Longfield Solar Farm

Statement of Common Ground – Environment Agency

Document Reference: EN010118/EX/8.4(B)

November 2022

Figure 1: Fluvial Flood Zones including indicative concept design (Figure 9-2b [EN010118/APP/6.3])

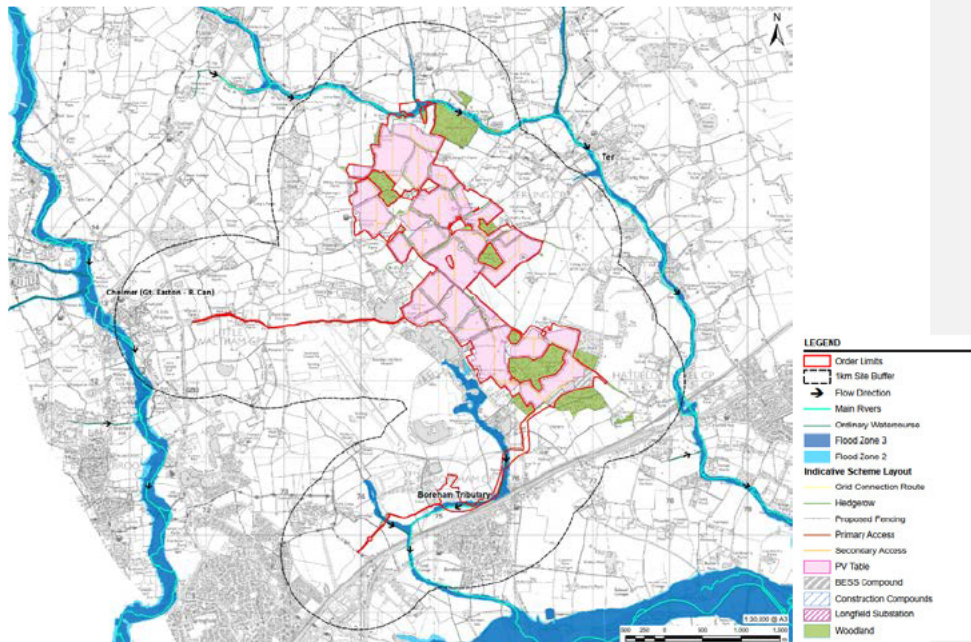
12	Development areas and Flood Zones	Appendix A of the FRA shows the layout of the development. It should also have a map showing built development in relation to the flood zones (including climate change, for the lifetime of development and beyond, as a sensitivity test). [Statutory consultation]	The updated FRA is available in Appendix 9A Flood Risk Assessment [EN010118/APP/6.2] . Figure 3 shows areas where above ground development may be located in relation to Flood Zones.	Agreed
